HERTFORDSHIRE BIOLOGICAL RECORDS CENTRE

Ask for: B. Tranter
Our Ref:
Your Ref: S6/2012/2608/MA
Tel: 01992 556155
Date: 04/01/2013

Planning application: S6/2012/2608/MA. Nyn Park, Well Road. Replacement boundary fence to Nyn Park Estate.

TITLE
Proposed Boundary Fence (60f6)

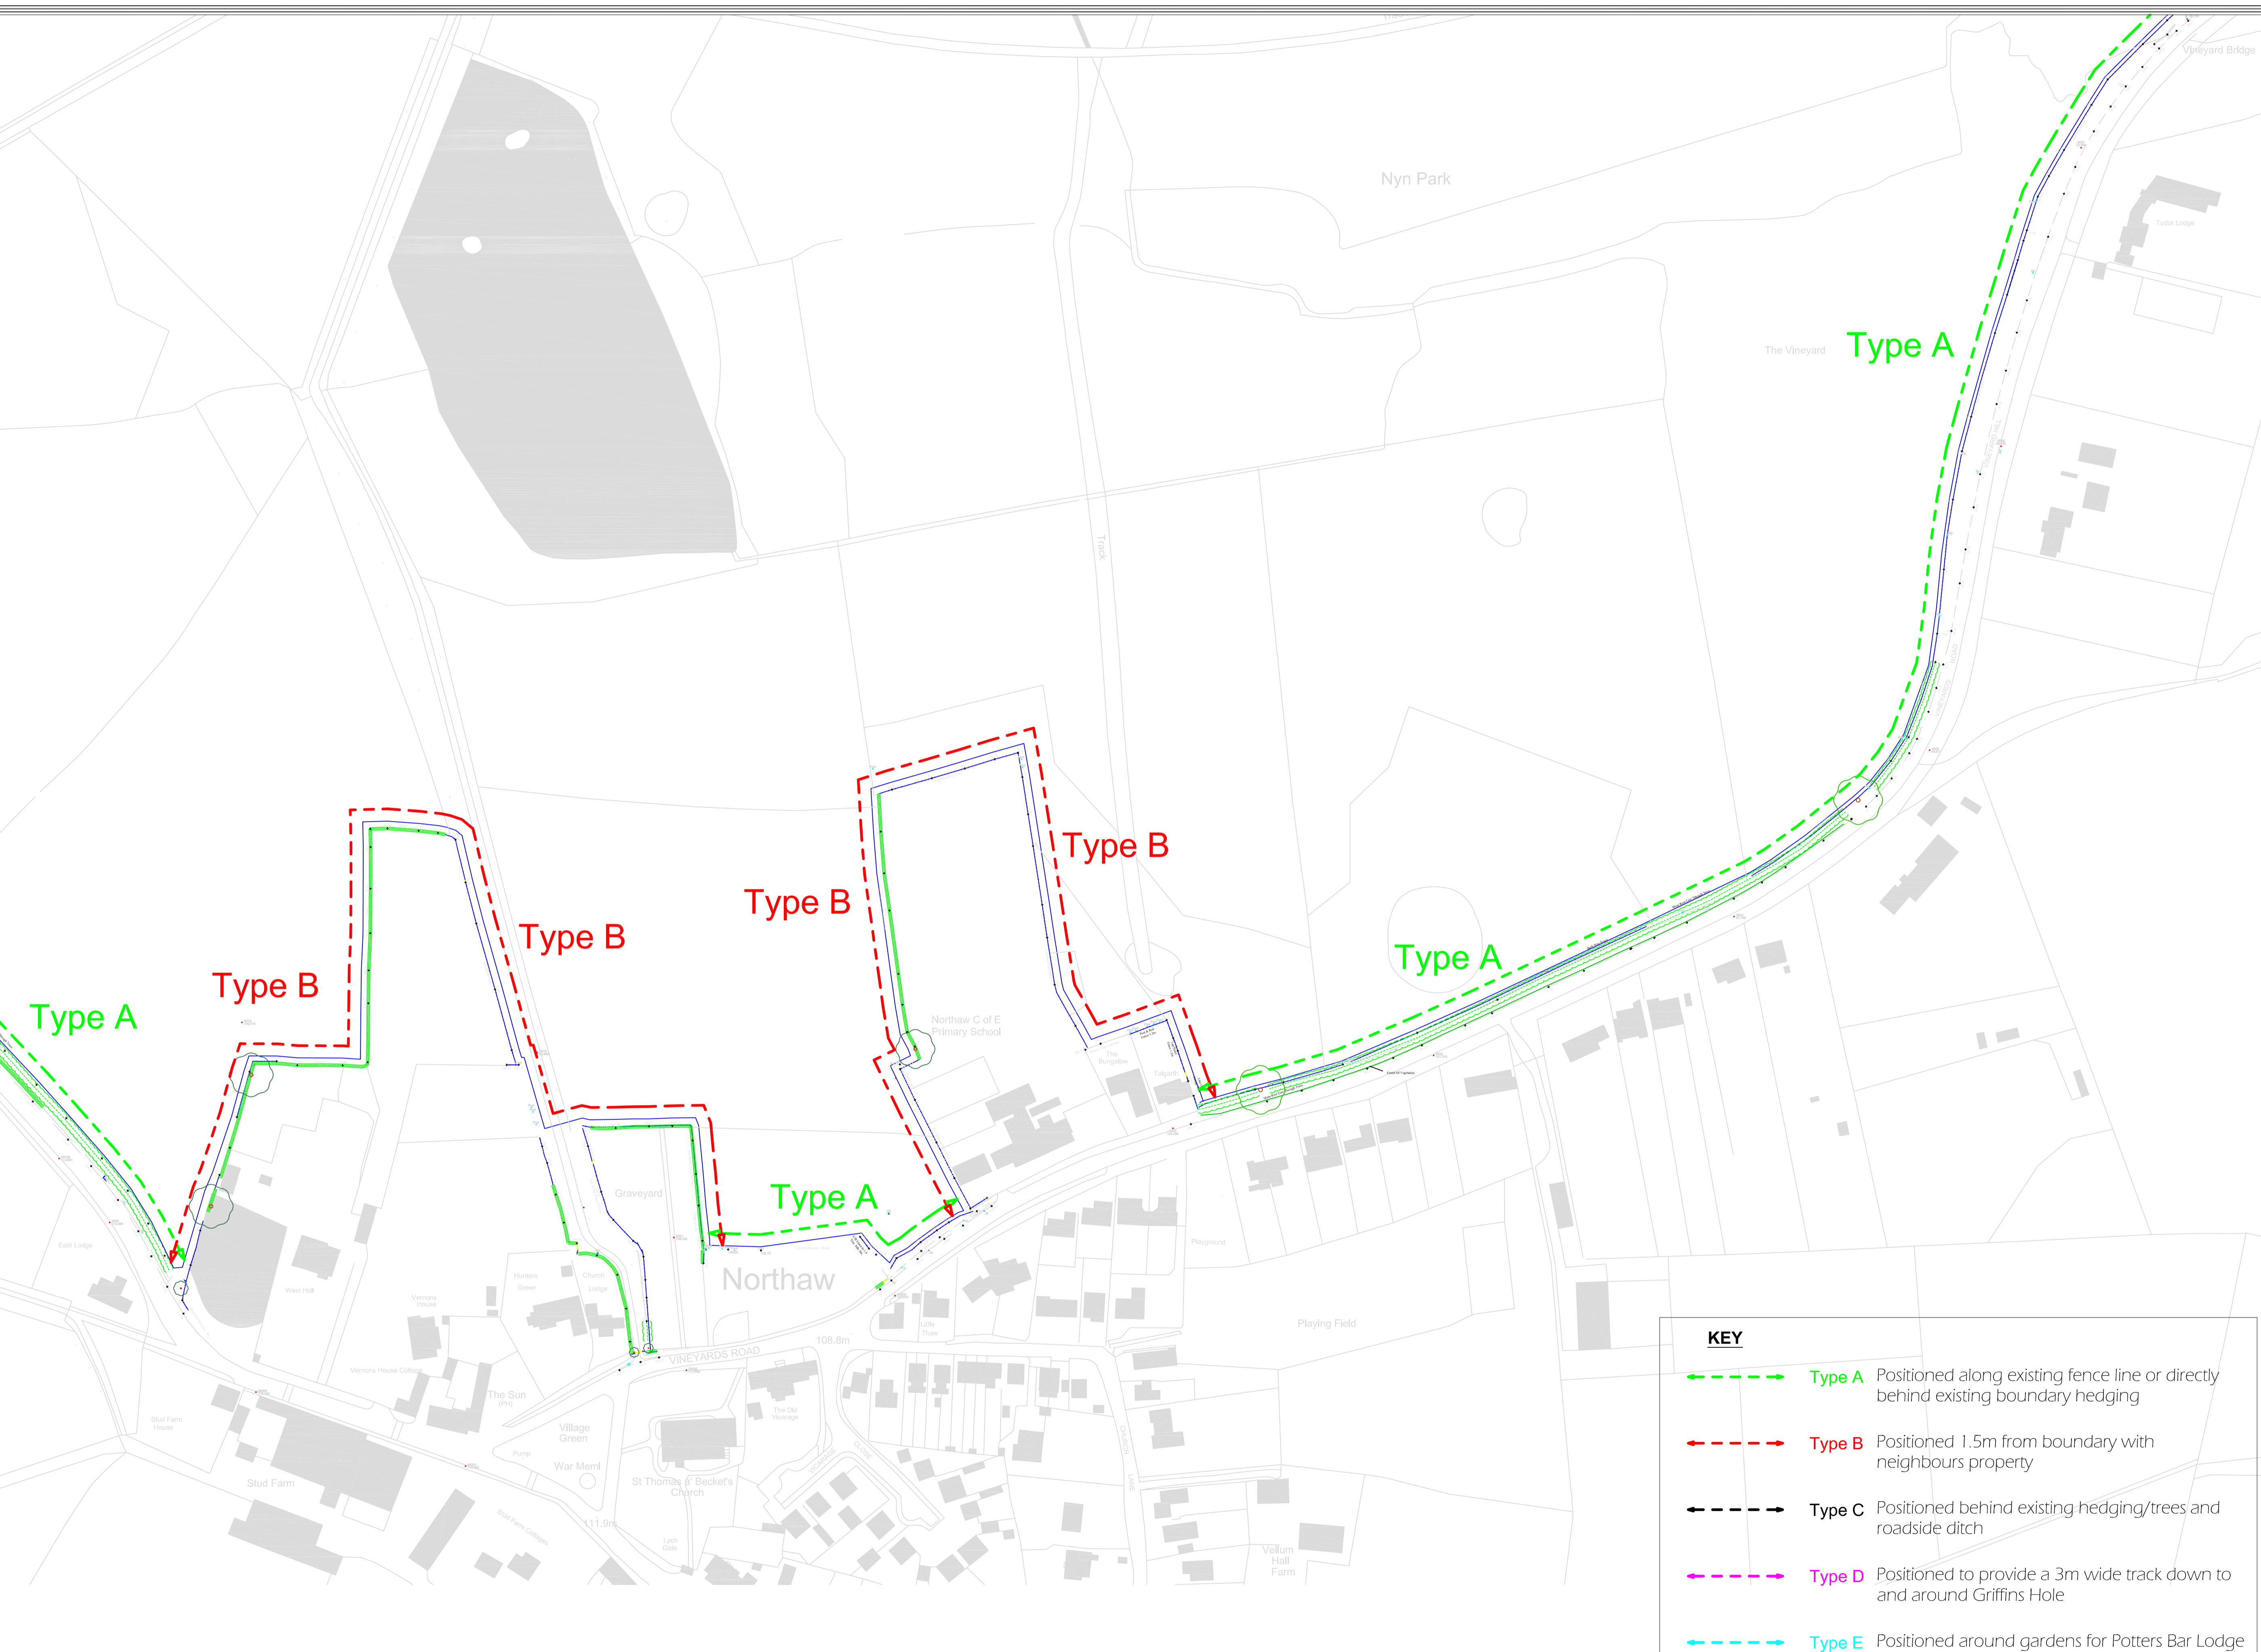
- a) The proposal states that the new fencing is to be set behind the existing hedge lines and that the hedges will be retained and further planted to infill gaps. We are happy with this arrangement as existing hedge lines will be kept and enhanced.

- b) Parts of the existing boundary for example within Well Wood and The Vineyard Wildlife Site, appear to be wooded and without boundary hedgerows. The construction of the fencing will obviously impact these habitats. Works must cause as little disturbance as possible to the ground flora which is often at its most diverse around the perimeter of woodlands. In addition, ancient features such as boundary banks may also be present and these should be protected.

- d) As Well Wood is part of a SSSI Natural England must be informed of the proposals, as the works may impact the SSSI.
